From: Nick Goddard
Sent: 22 February 2021 13:29
To: Adam Walker
Subject: RE: Proposed new Lidl store at New Hey Road - Response to Tree Officer Comments [NLP-DMS.FID496520]

Nick Goddard
Arboricultural Officer

Type D Retaining Wall
Scale 1:50

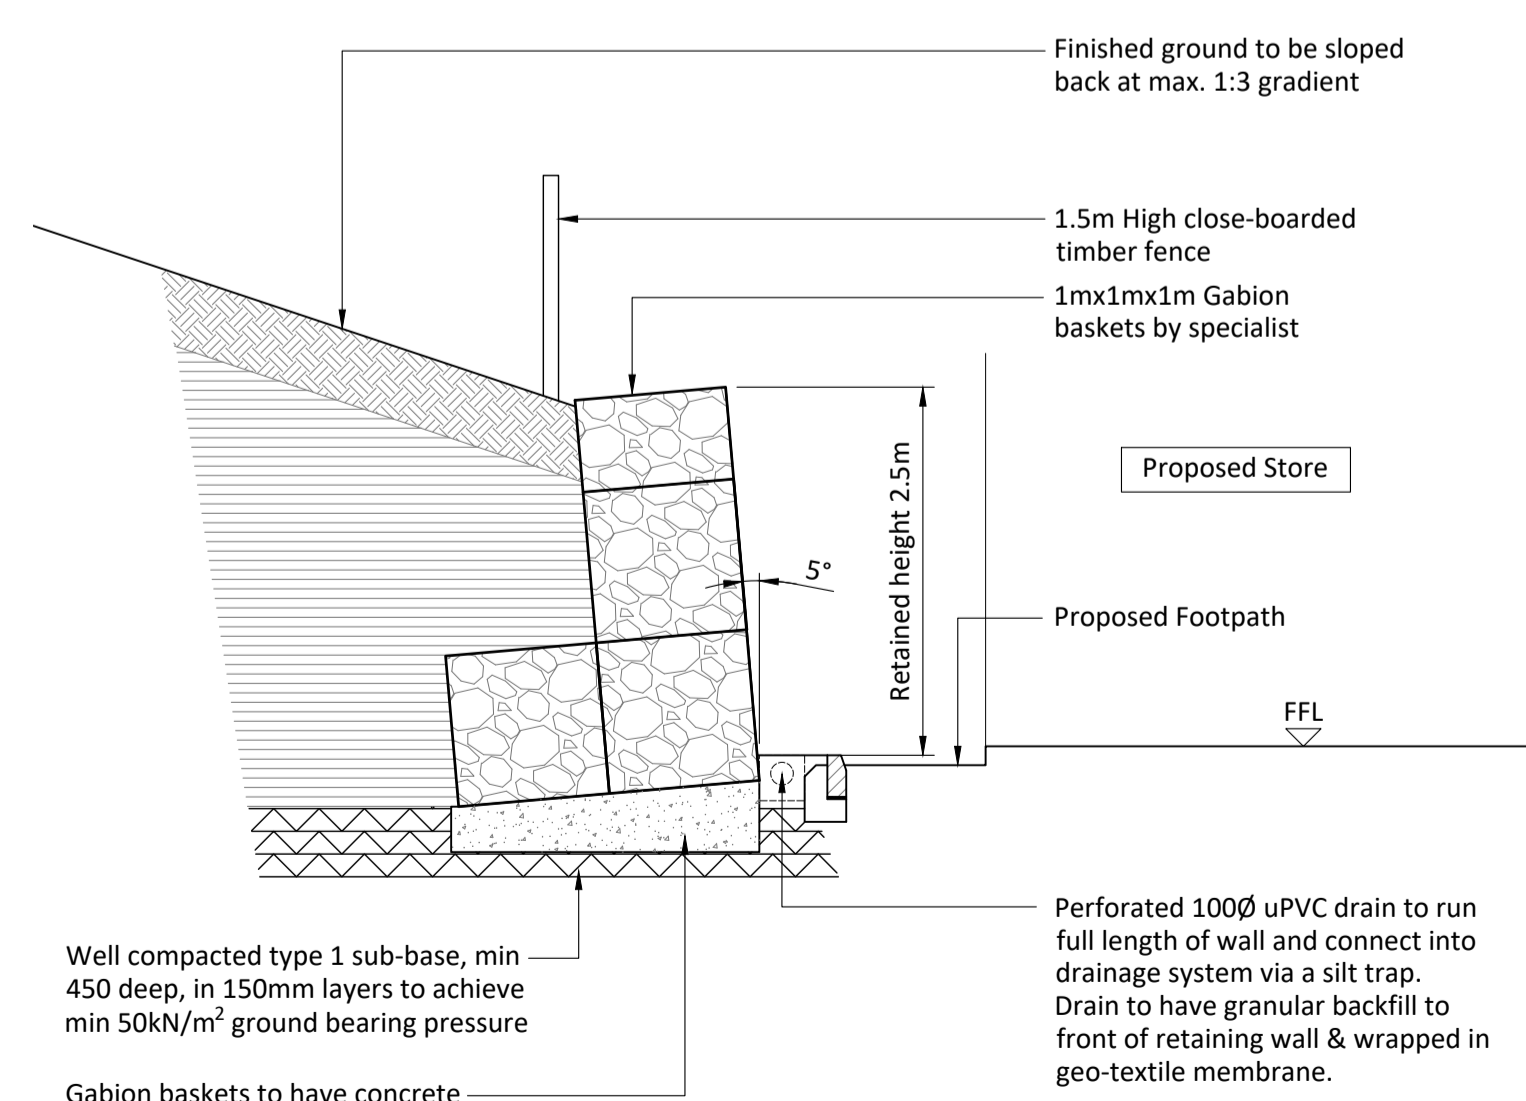
The retaining wall along the service yard area, adjacent to G13, is shown as retaining wall type D, which shows no change to ground level behind it. I would ask therefore why all the plans for the site show chevrons pointing in to the site. This indicates a banking at this point, something which does not exist at present and the Council should ensure is not permitted by these proposals because, and I think everyone agrees, grading the ground in the RPA of protected trees would be harmful to them.

Any contractor carrying out ground works on the site is going to see chevrons, demarking grading under the canopy of these trees, on every single plan except for the Retaining Wall Sections drawing, 09-122-411. I hope this was a simple oversight when the proposals were drawn and then copied in to every other relevant plan. The Retaining Wall General Arrangement shows grading; the Proposed Boundary Treatments Site Plan shows grading; the Proposed Site Plan with tracking shows grading. It is all too easy to envisage the land being graded by a contractor as a result of these plans, and whether this is done by mistake or not the harm to the trees this would cause would be permanent.

- The tree officer's response queried the impact on the existing trees from what they perceived as the grading of land between the trees and the retaining walls near the delivery bay. We can confirm that there will be no changes in levels to this land. The retaining walls are proposed in this location for the precise reason of maintaining existing ground levels in tree rooting zones
- No works are proposed to the existing culvert within the tree routing zones – the culvert diversion is located outside the influencing distance of trees. This has been annotated on the drawings within the AIA for clarity.
- There will need to be some root pruning for T5 and G15 for the car park and lighting column. It should be noted that the degree of root pruning required is minimal and is considered to have little impact on the long-term health of the trees in question.

Appendix 7: Arboricultural Implications Plan

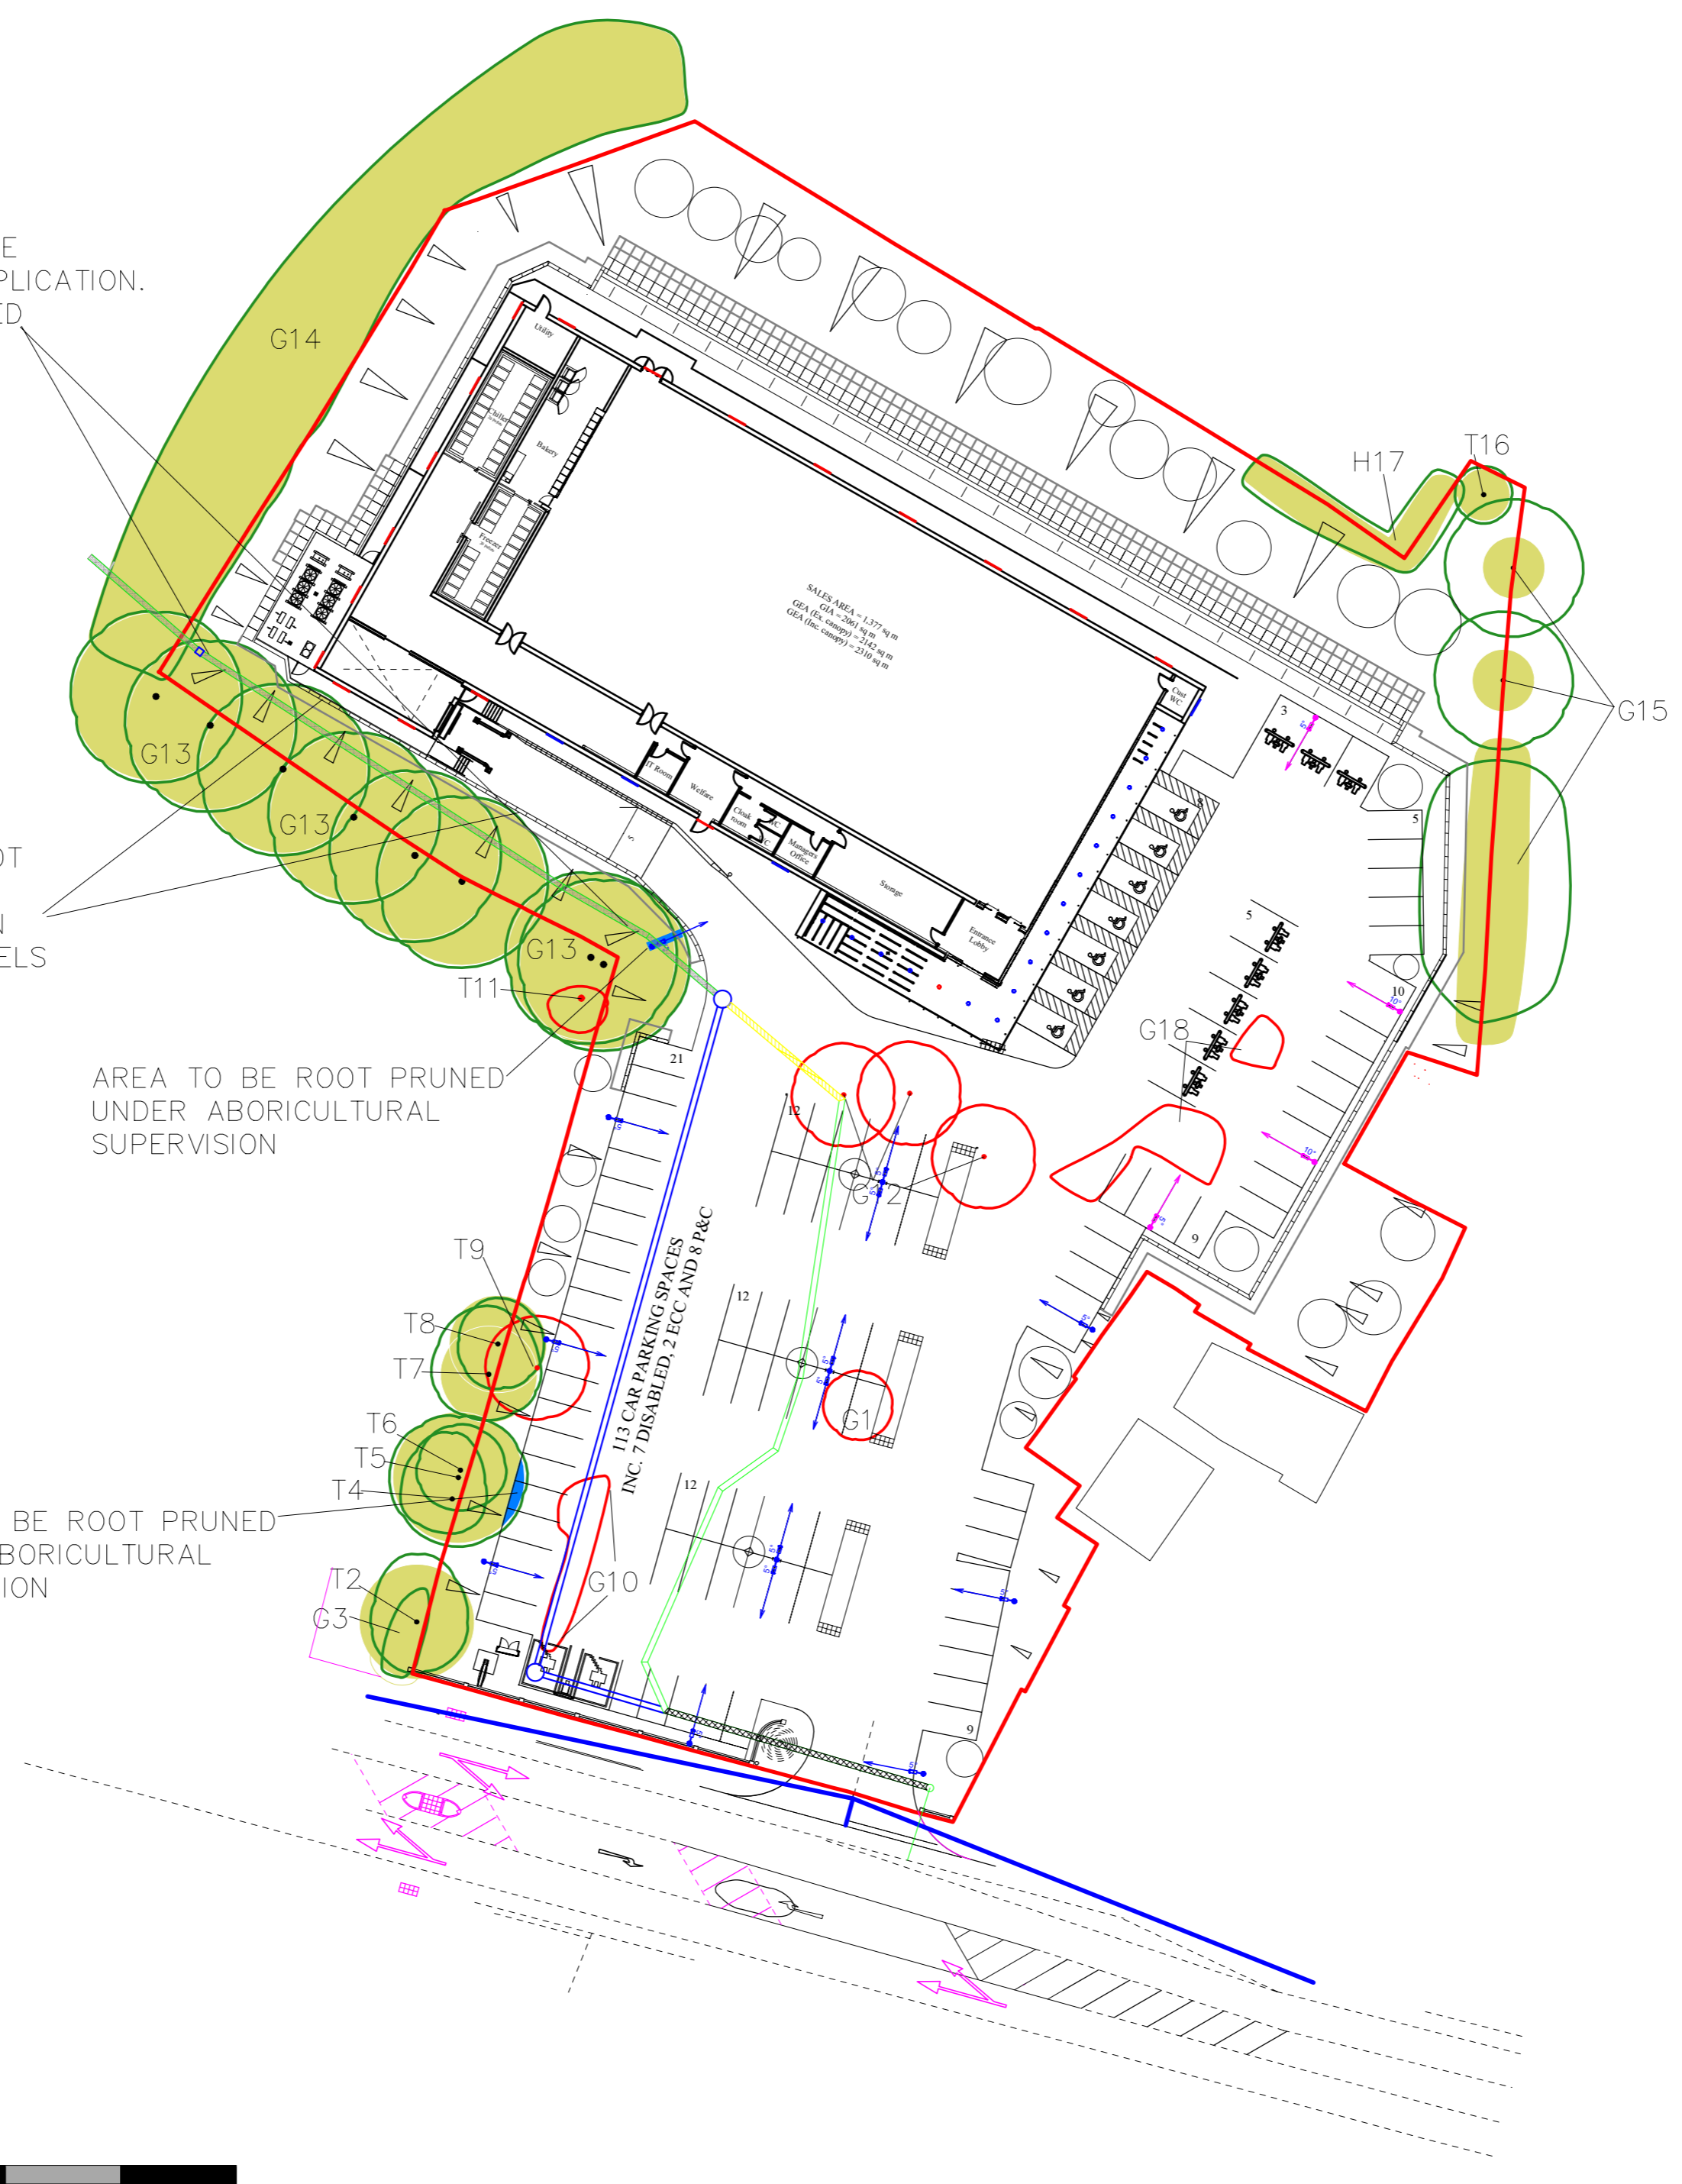
I can see that there is now an annotation on the TPP to say no works are proposed for the existing culvert under this application. My problem is however, that the Culvert Diversion General Arrangement shows a Phase 3 which is to repair any collapsed and damaged sections of the culvert within the RPA of G13. This was why I raised my concerns in the first place and this has not altered as far as I can tell. Is this plan not forming part of this application?

Again I can see that the AIA and AMS now reflect that there is a lighting column in the RPA of G13 however my question was, can it be moved? It does not appear that the lighting column has been moved nor any explanation as to why it cannot be moved outside of the RPA of G13. I appreciate that the root pruning may be minor however the principle of BS5837, is that impacts should be avoided first. Given the proximity of the retaining wall works along the service yard and the impact to the RPA of G13 from the car park retaining wall I think it is not too much to ask that an alternative location for the lighting column be explored.

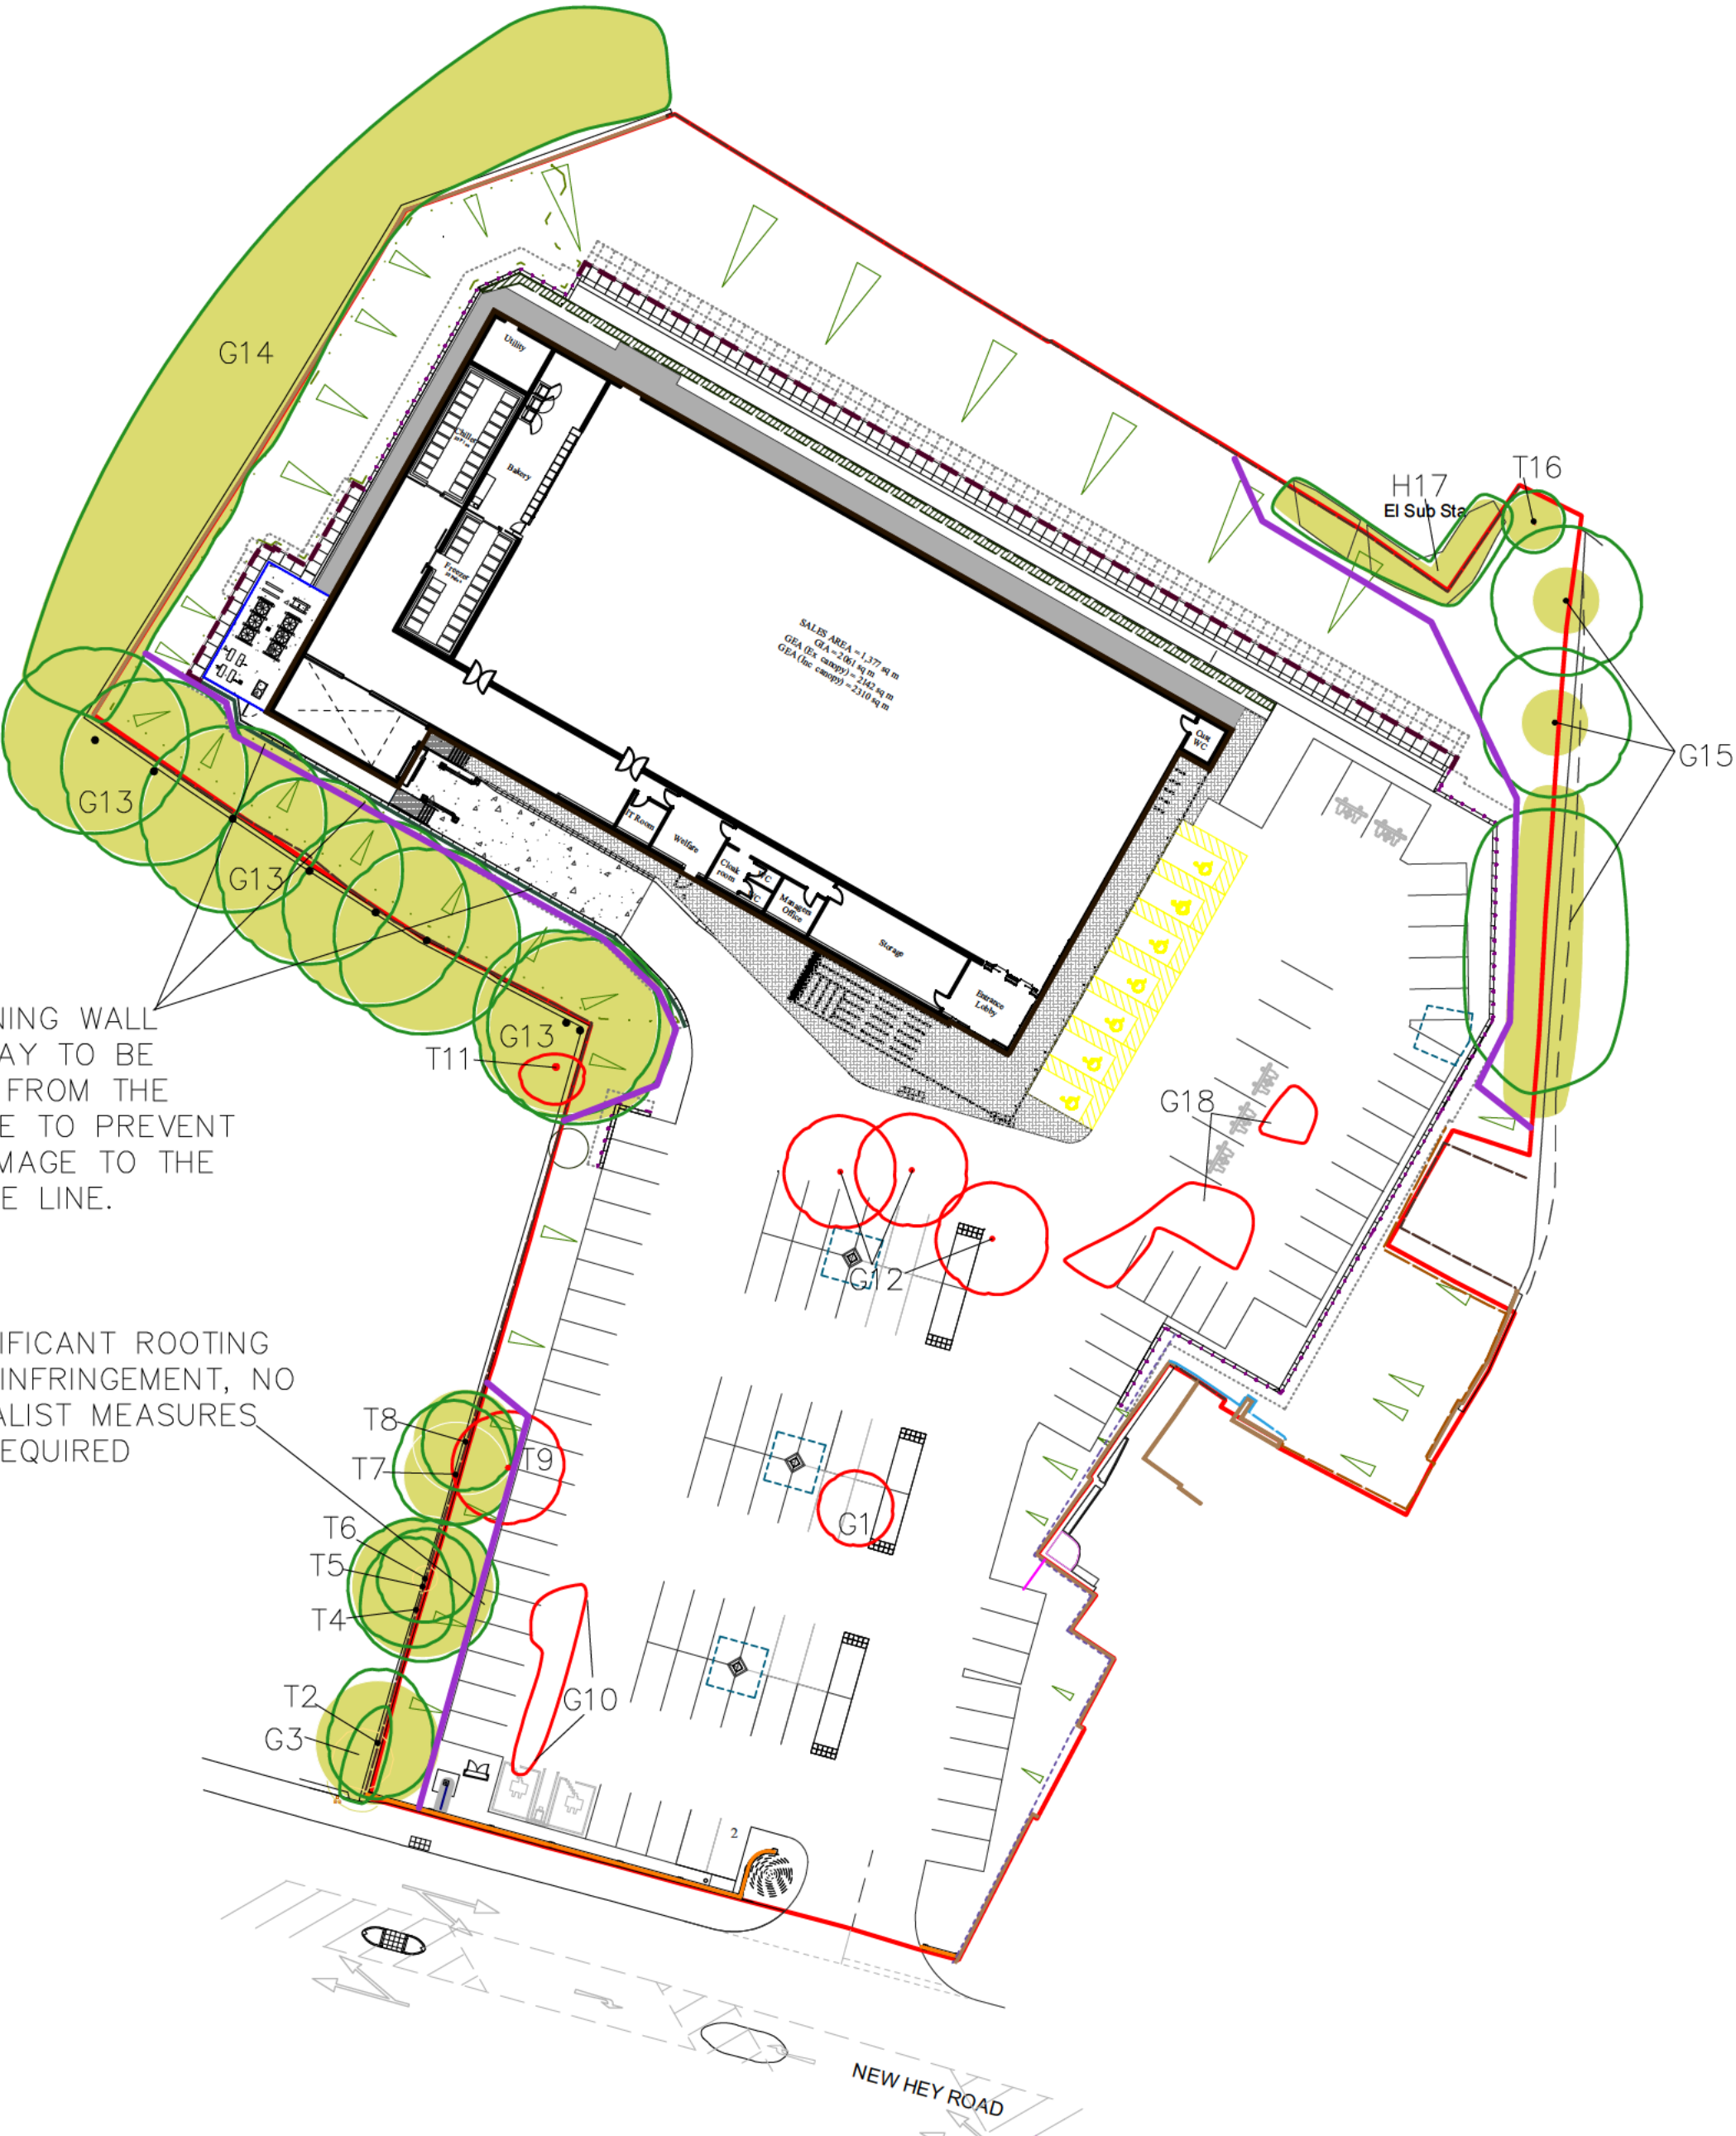
The Tree Protection Plan, ref 16383-B/AJB, shows a protective fence line going across a retaining wall in the TPA of G13. The wall is to be constructed using sheet piling and presumably will require the same hand dug trench to find and sever roots as has been applied to T5. The plan needs to show blue in that area and the fence location needs to be such that the wall can actually be constructed which at present it can't. I assume this is an oversight and can be easily rectified.
